Consultation Response from KC, Trees
2023/91002 Corby, Birkby Road, Birkby, Huddersfield, HD2 2DR
Erection of two storey rear extension incorporating a roof terrace, single storey side and rear extensions incorporating a roof terrace, two storey feature entrance, garage/home office outbuilding and landscaping works including the formation of a tennis court with associated fencing and the creation of pedestrian access and alterations.
Date Responded: 14/08/2023 Responding Officer: D. Atkinson Responding Ref: 46/90 and 17/85

drawing
Proposed Site Plan, Site Sections and Proposed garage/home office

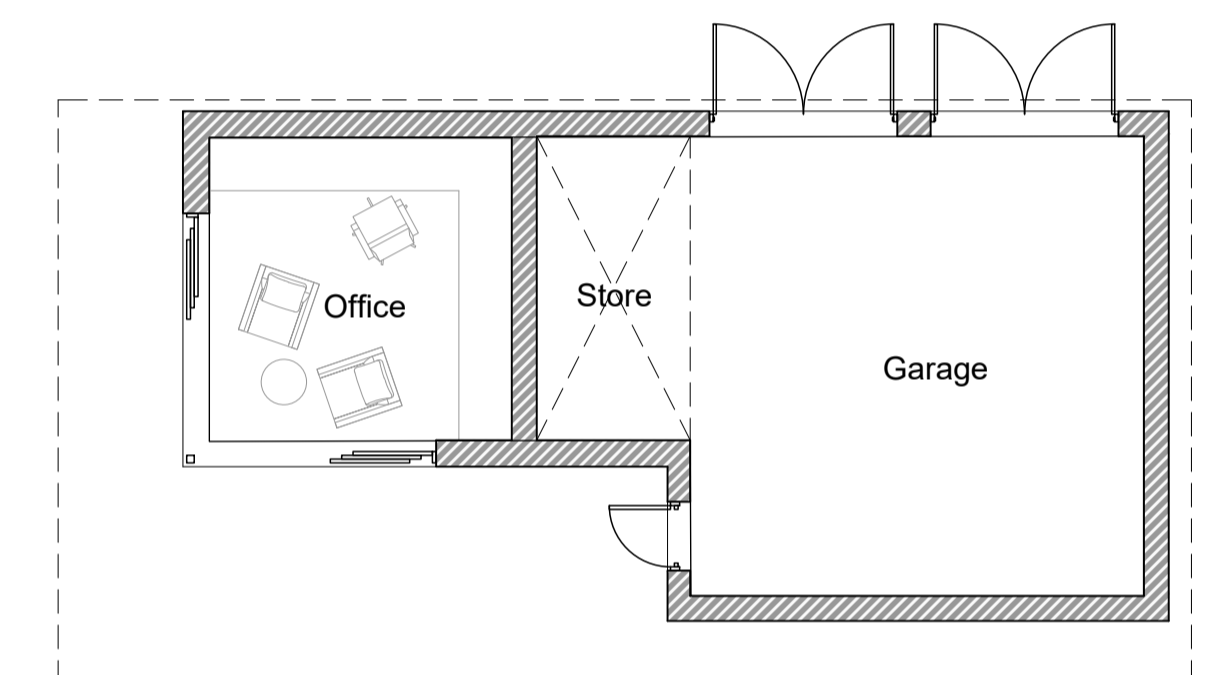
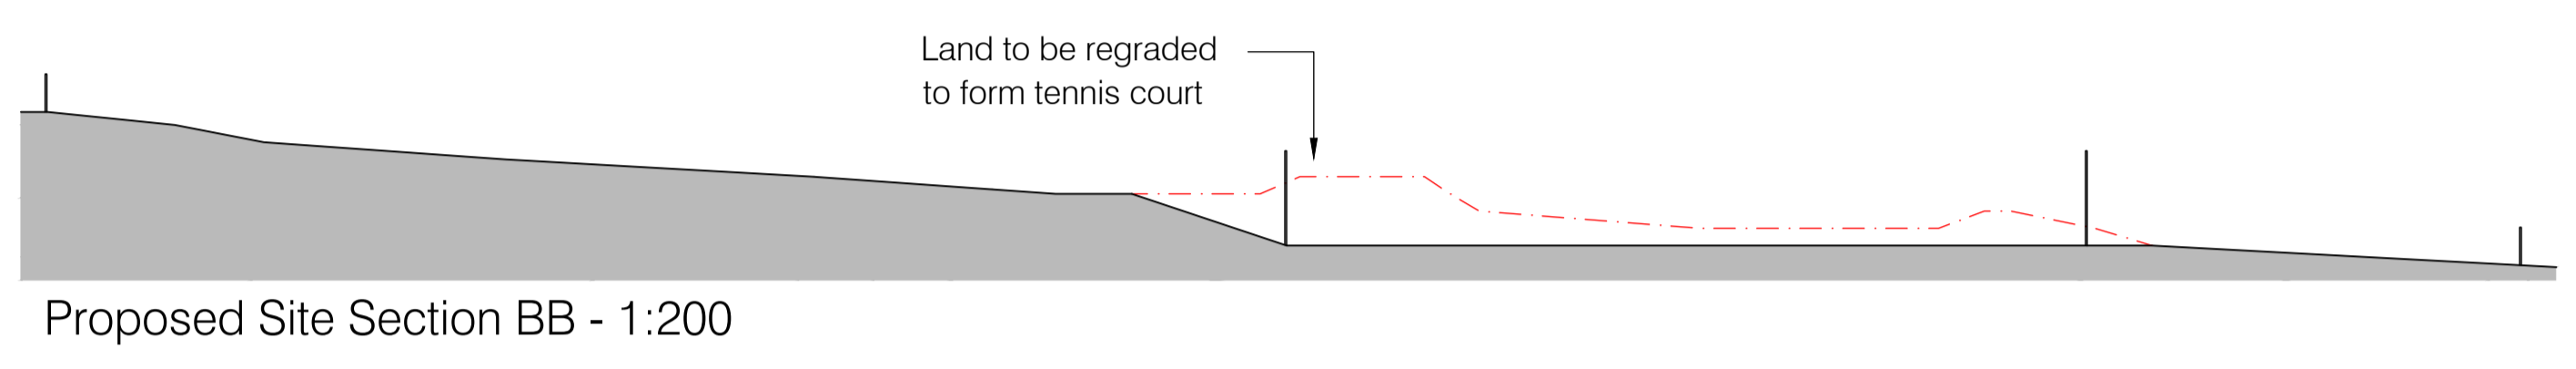
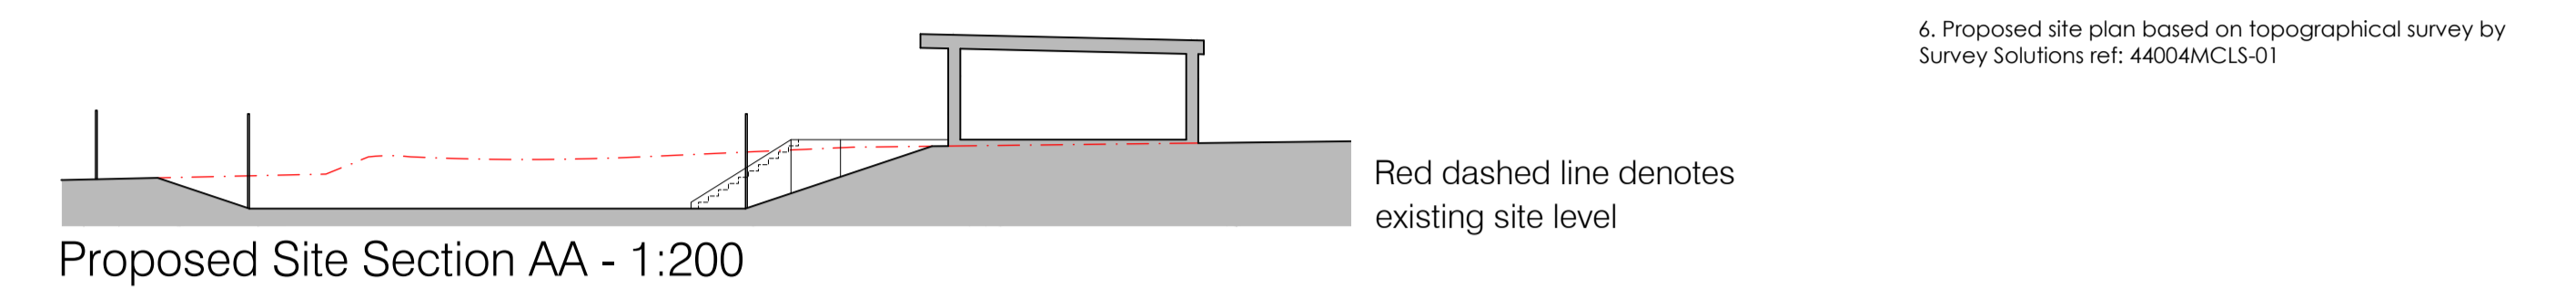
However, trees within/overhanging from properties on Inglewood Avenue that are subject to 17/85 haven't been surveyed or assessed. This is important as the construction and levelling required from the proposed tennis court could impact on the trees and vice-versa.

In order to progress this proposal, we would need to see an arboricultural impact assessment to help understand the impact this proposal could have on existing trees and an arboricultural method statement to show how this work can be done without causing harm to trees or their roots. If the access needed to facilitate this work is to be the driveway running alongside these trees how will this be done without damage being caused for the trees along the Inglewood Avenue boundary.

client  
 Dr I Gilkar  
 project  
 Corby, Birkby Road, Huddersfield, HD2 2DR  
 drawing  
 Existing and Proposed Block Plans

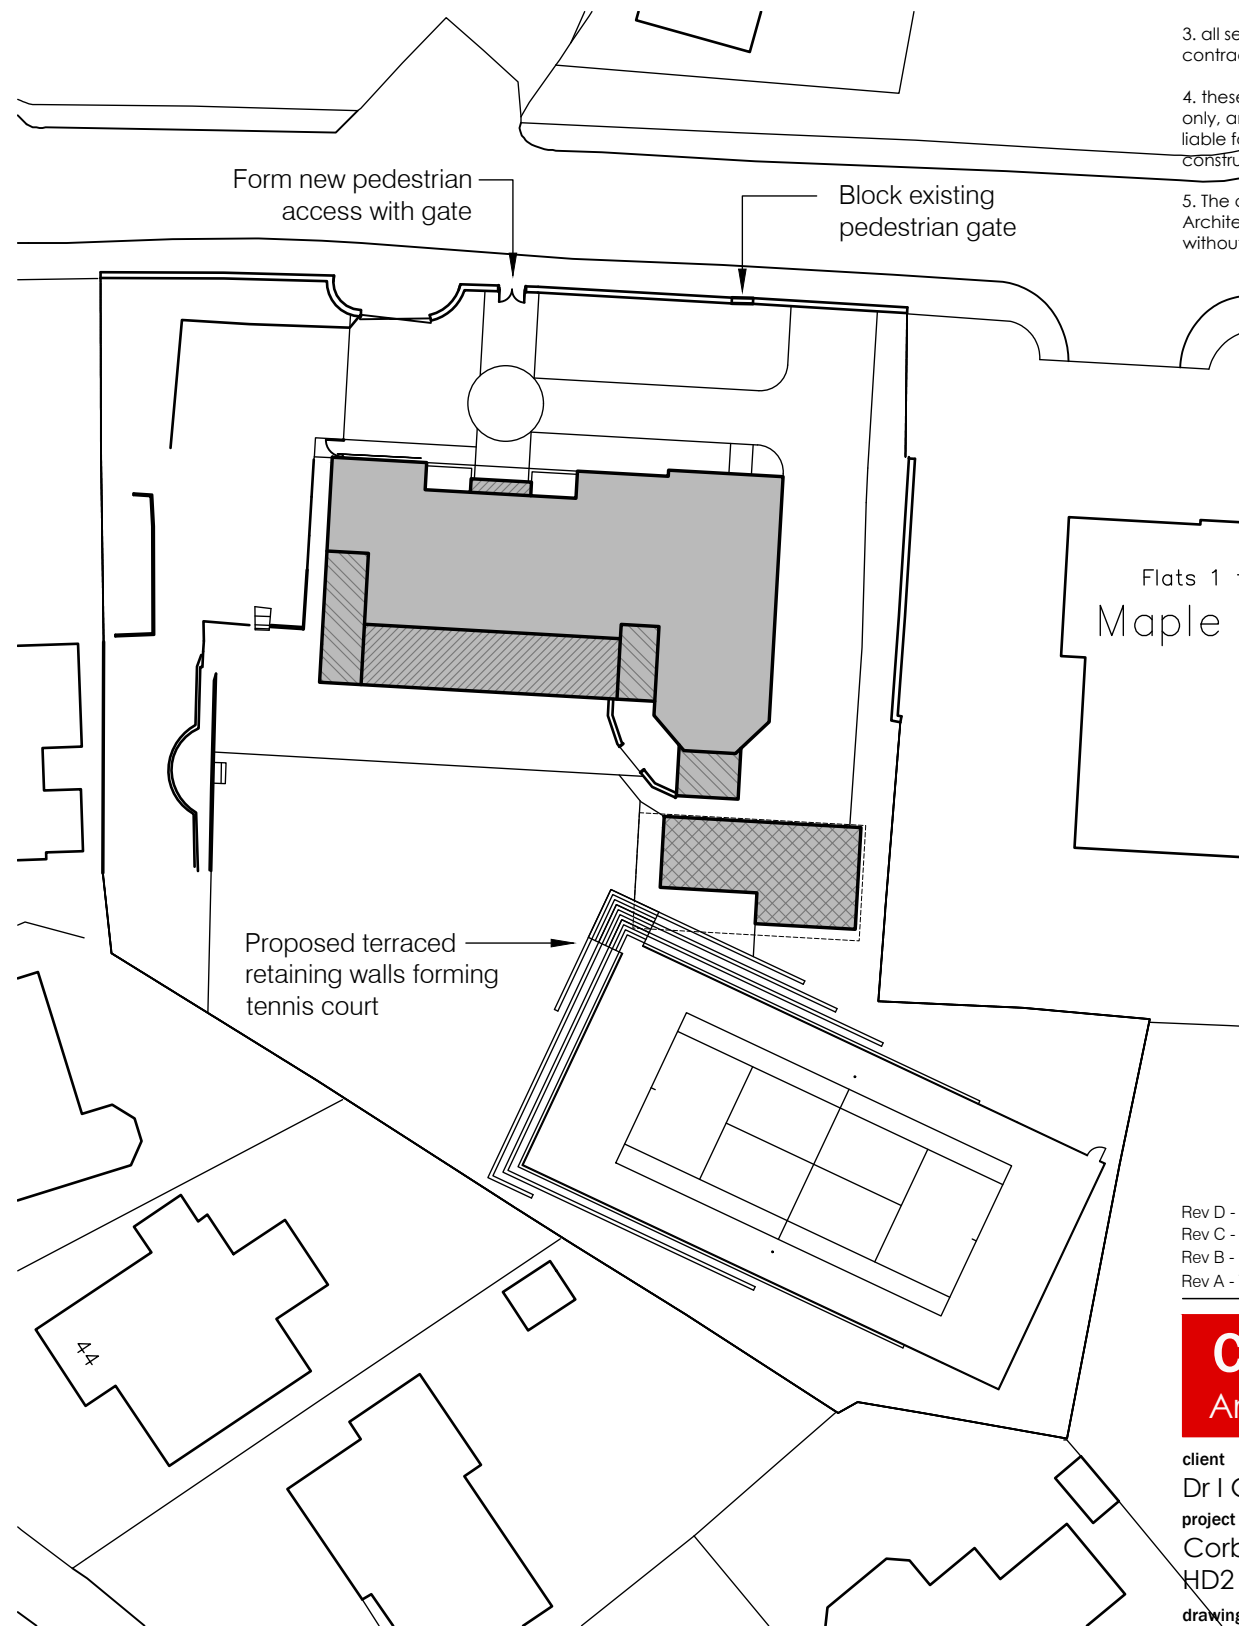
The garage being moved to along this boundary will foreseeably mean the increase of cars and vehicles etc. being parked along this boundary and under the canopies of the trees.

This could lead to increased pressure to prune the trees in order to reduce nuisance like honeydew, bird droppings and seasonal debris affecting them while parked.
